**Re: treeiQ Response to Submission for SSD 7081 – Faculty of Arts and Social Sciences (FASS) Building**

Please see below our response in relation to the tree management issues raised by Office of the Government Architect regarding the proposed FASS project. Specifically, the submission outlines that the scope of landscaping works and alignment of the eastern entry path should be reconsidered to preserve the health of significant trees.

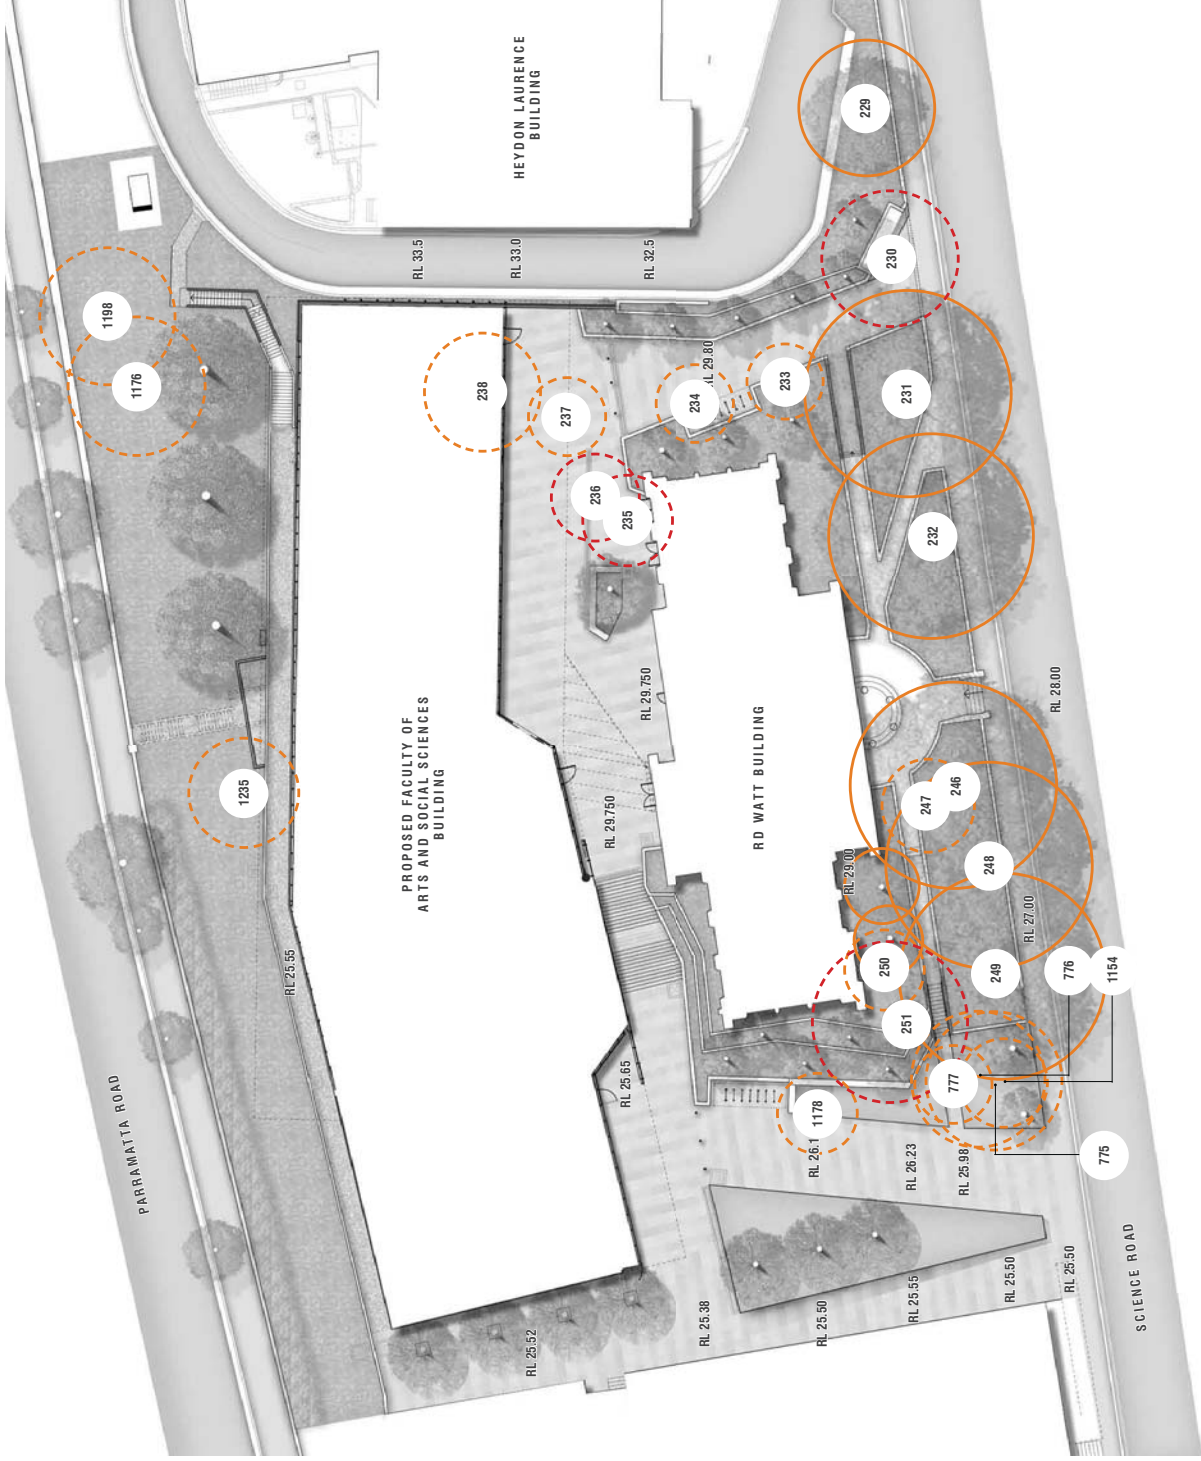
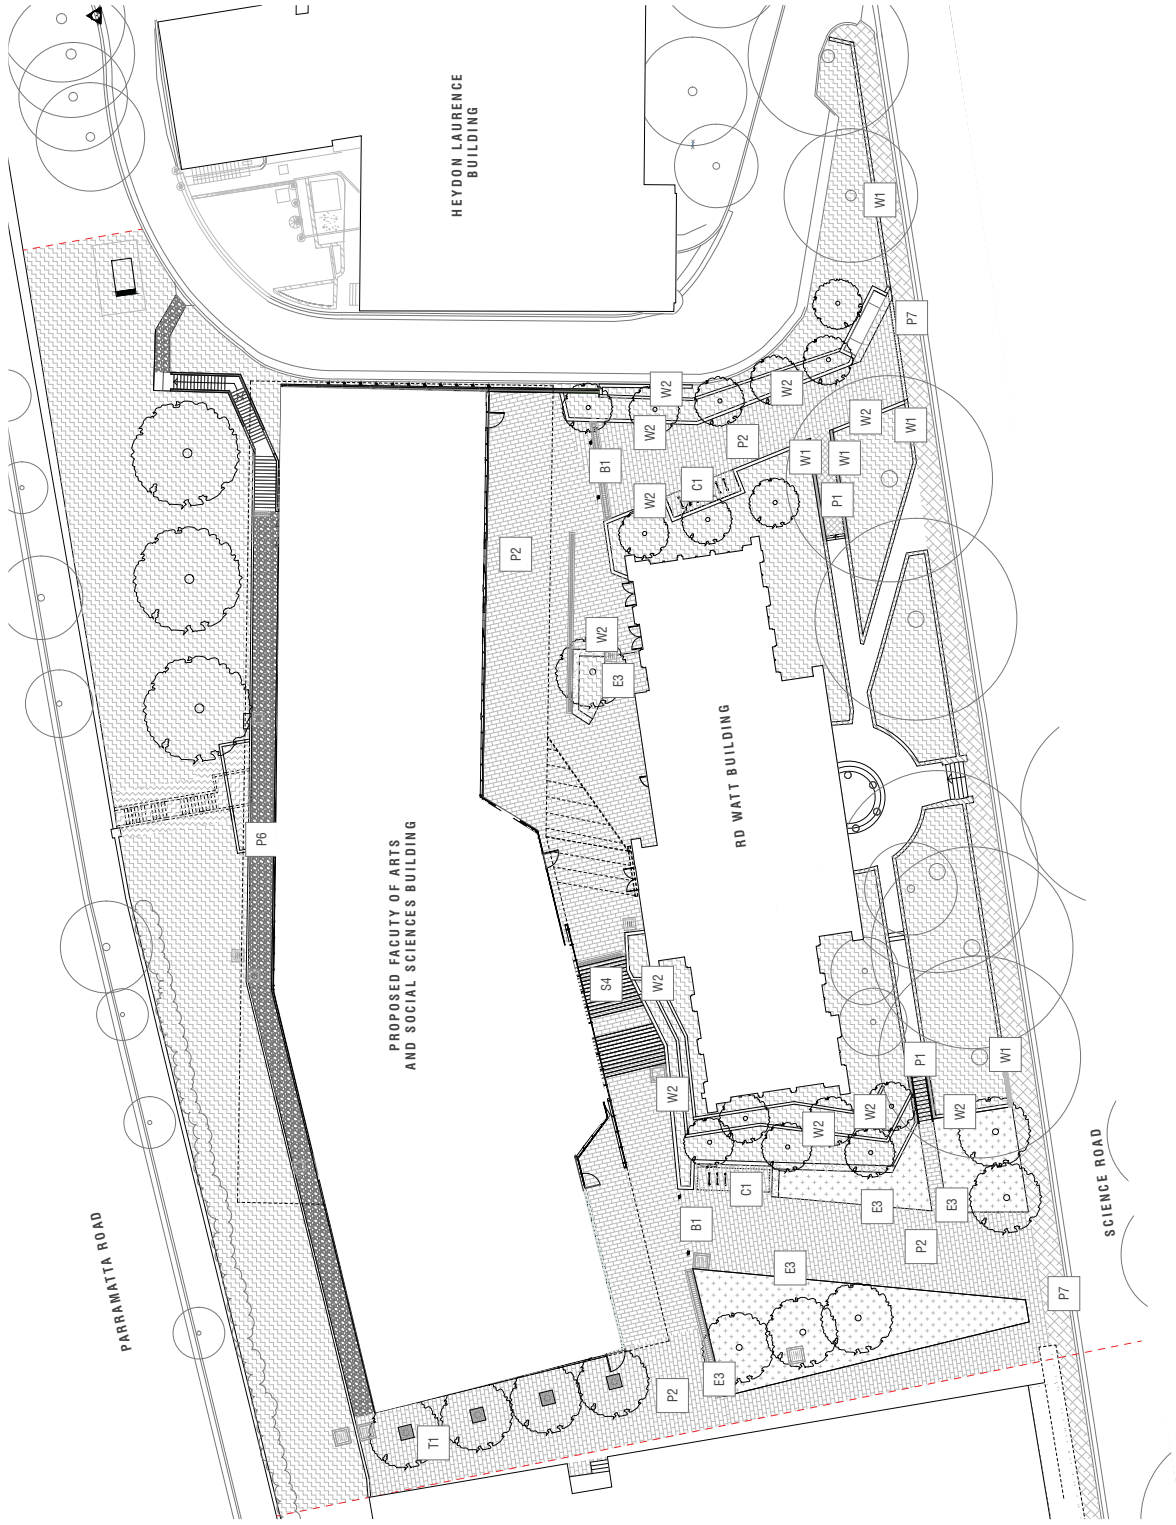
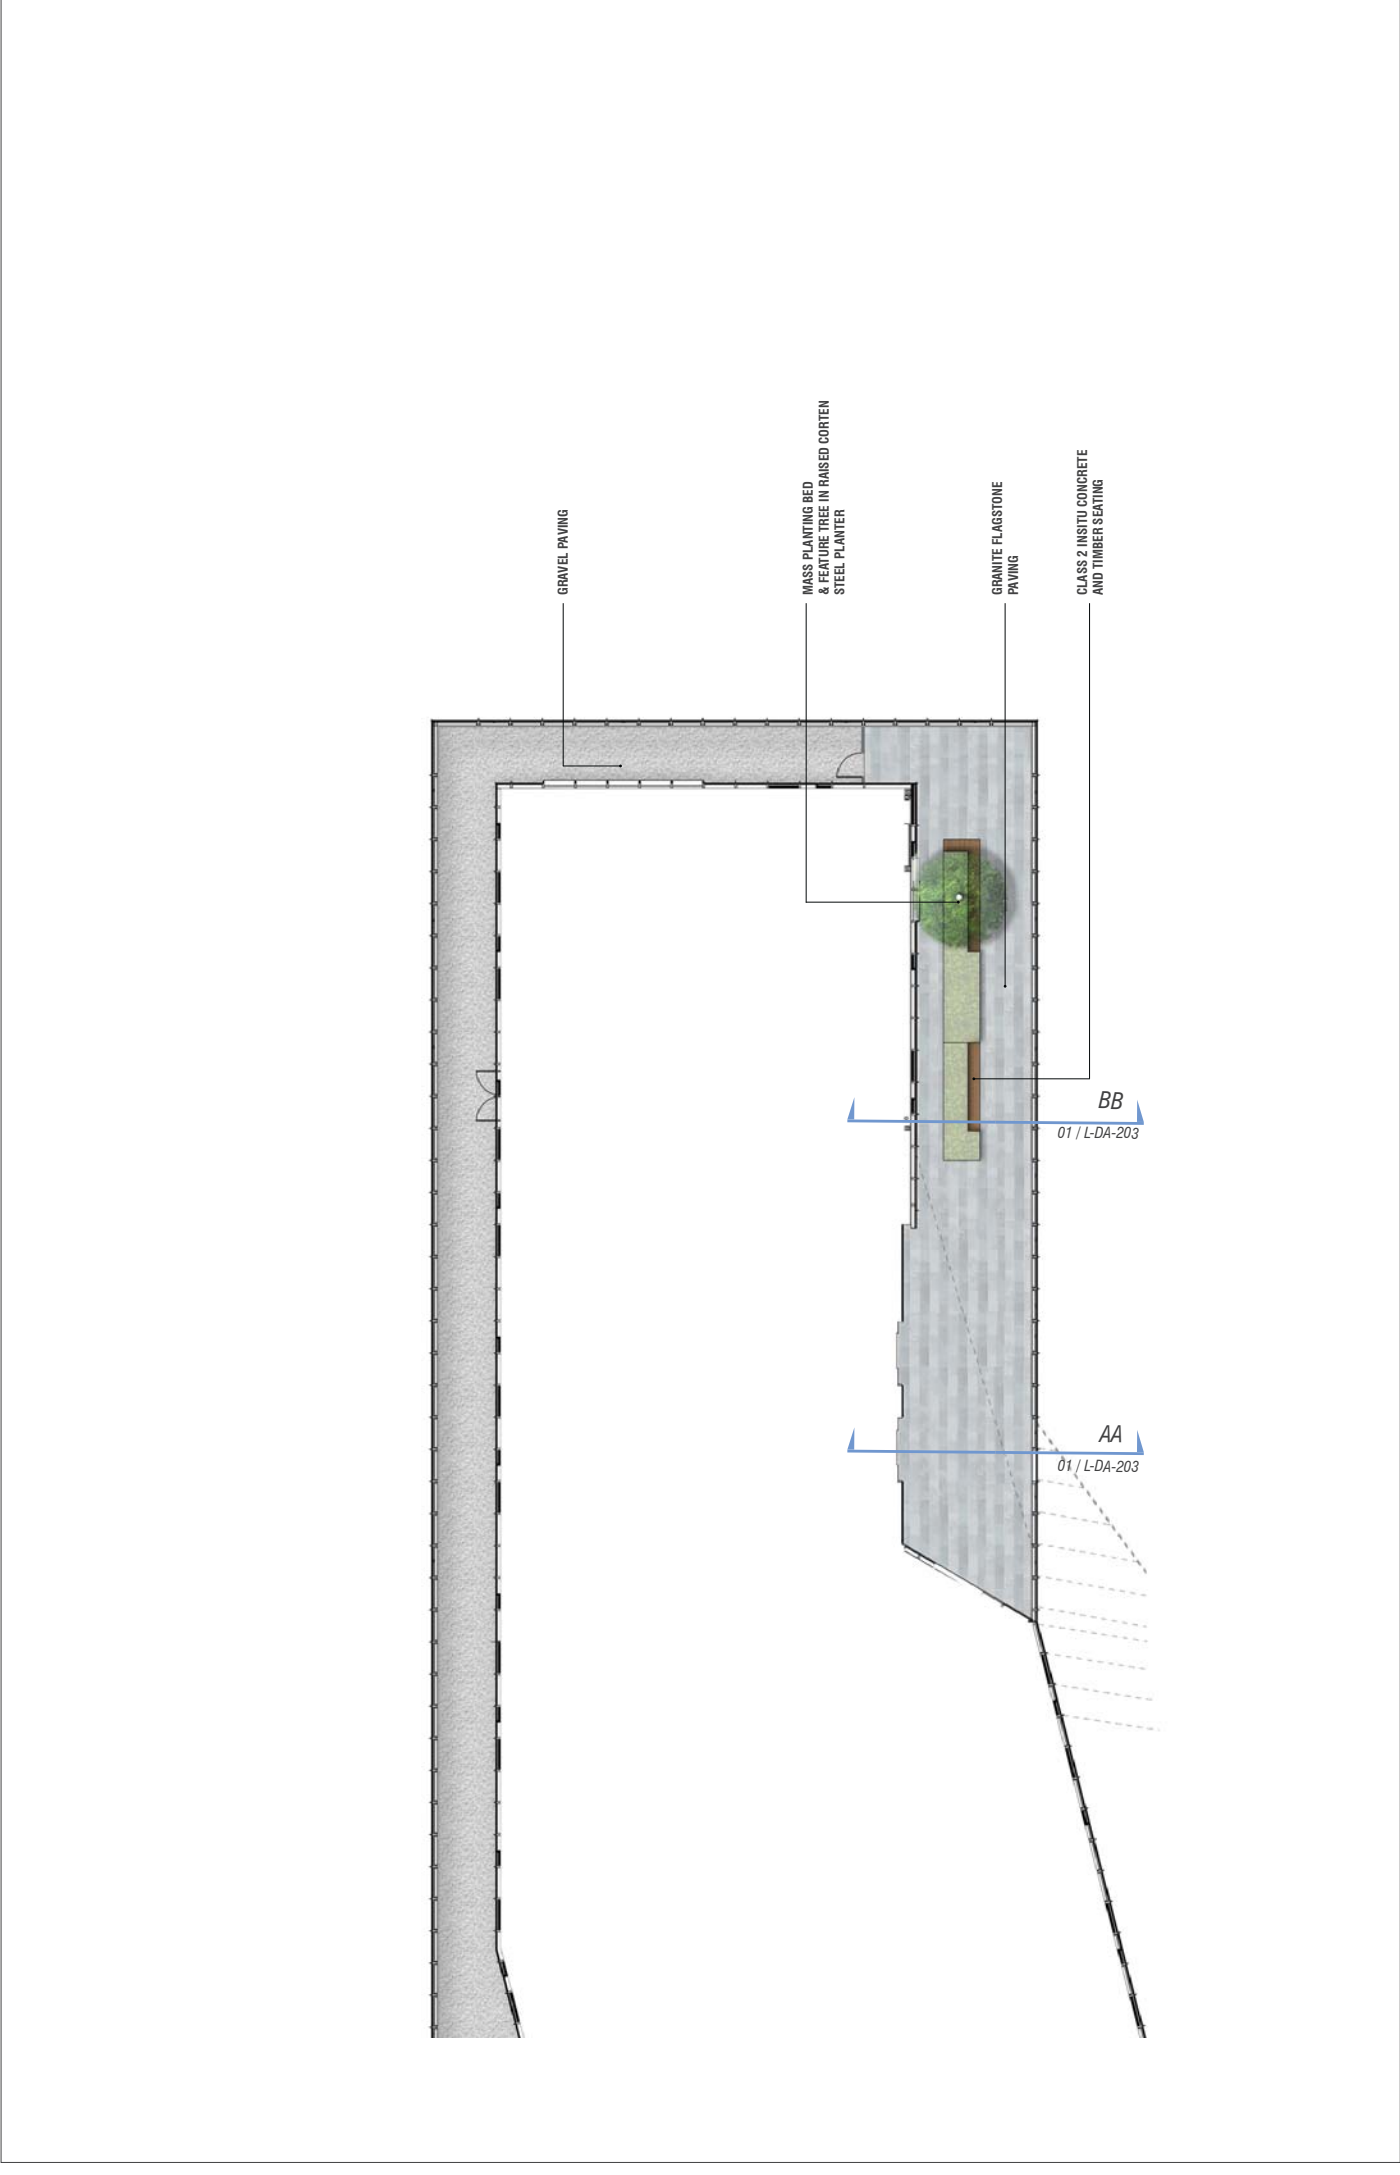
Tree 230 is identified as a *Lophostemon confertus* (Brush Box) and is proposed for removal. Tree 230 is in fair health due to dieback in upper crown, and the presence of small (<25mm) diameter deadwood and small (<25mm) diameter epicormic growth.

Trees 229 and 231 are identified as a *Lophostemon confertus* (Brush Box) and are proposed for retention. Tree 229 will be subject to Tree Protection Zone (TPZ) encroachment from the sandstone wall reconstruction. These works represents a *Minor Encroachment* (less than 10% of the TPZ) as defined by *Australian Standard 4970 2009 Protection of Trees on Development Sites* (AS-4970). A Minor Encroachment is considered acceptable by AS-4970 when it is compensated for elsewhere and contiguous within the TPZ.

Tree 231 will be subject to TPZ encroachment from the construction of the eastern entry path. These works represent approximately 18% of the TPZ area and are defined as a *Major Encroachment* by AS-4970.

Based on the above, it expected that with the use of best practice tree management during the development period as recommended in the Arboricultural Impact Assessment Report & Tree Protection Specification, these works should not significantly impact the health or Useful Life Expectancy of the Tree 231.

In addition, to limit the potential impact of encroachment on Tree 231 it is recommended that the layout of the footpath extension to the north of the tree should be flexible. In particular, the new steps should be positioned to allow for the retention of roots (>25mmØ) as determined by the Project Arborist. The most appropriate location for the steps could be determined by preliminary hand excavation/root mapping during the construction stage of the project. Furthermore, new retaining walls for the footpath extension should be constructed on piers rather than strip footings to minimise excavation in the TPZ. Piers locations should be hand excavated and positioned to avoid roots (>25mmØ) as determined by the Project Arborist.
